Standing up for the Warwickshire Countryside

2 September 2019

**Planning Act 2008**

**Application by Highways England for Order granting Development Consent for M42  
Junction 6 Improvement, Metropolitan Borough of Solihull  
Representations due 2 September 2019 on 'ExQ2'**

**STREETS, RIGHTS OF WAY AND ACCESS PLANS  
REGULATION 5(2)(K)  
SHEET 4 OF 7**

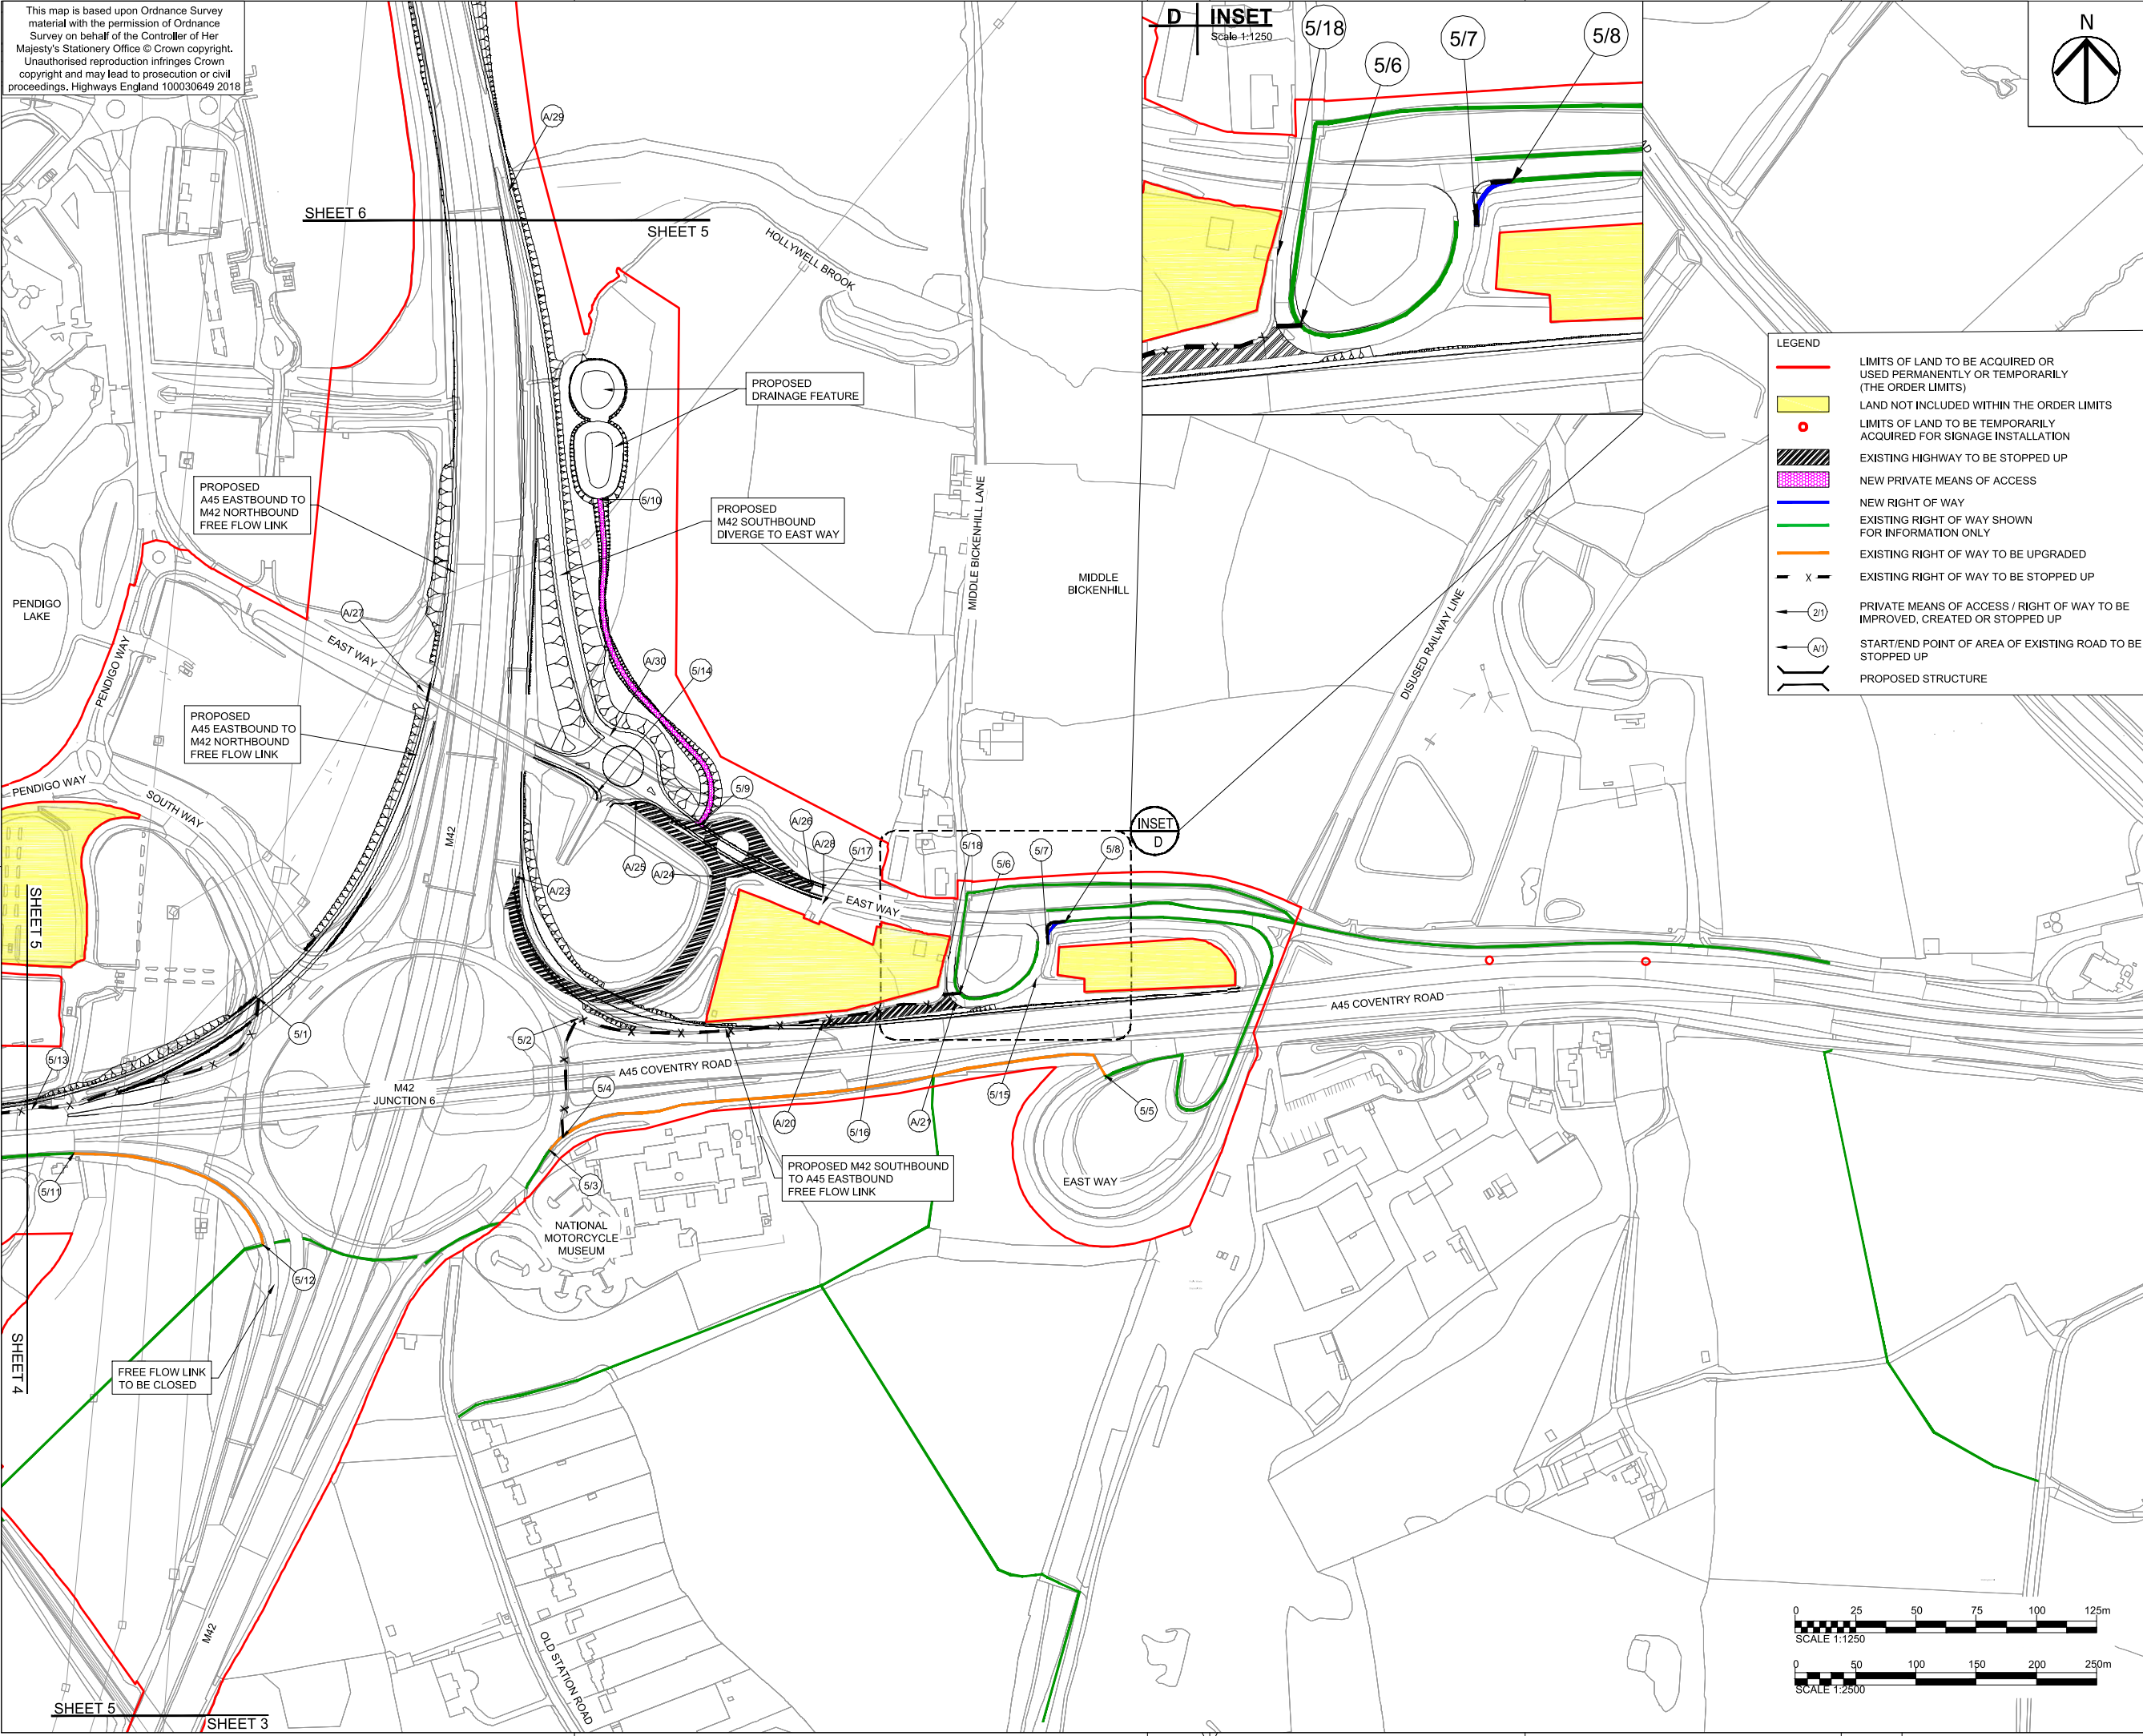
The current Application proposes to stop up a 'street' for which no substitute is to be provided. The B4438 is to be stopped up between points A/18 and A/19 shown on Sheet 4 of the Streets, RoW and Access Plans. See Draft Development Consent Order p64 Schedule 5 Part 2. The Order does not state the alternative route or that an alternative is not required.
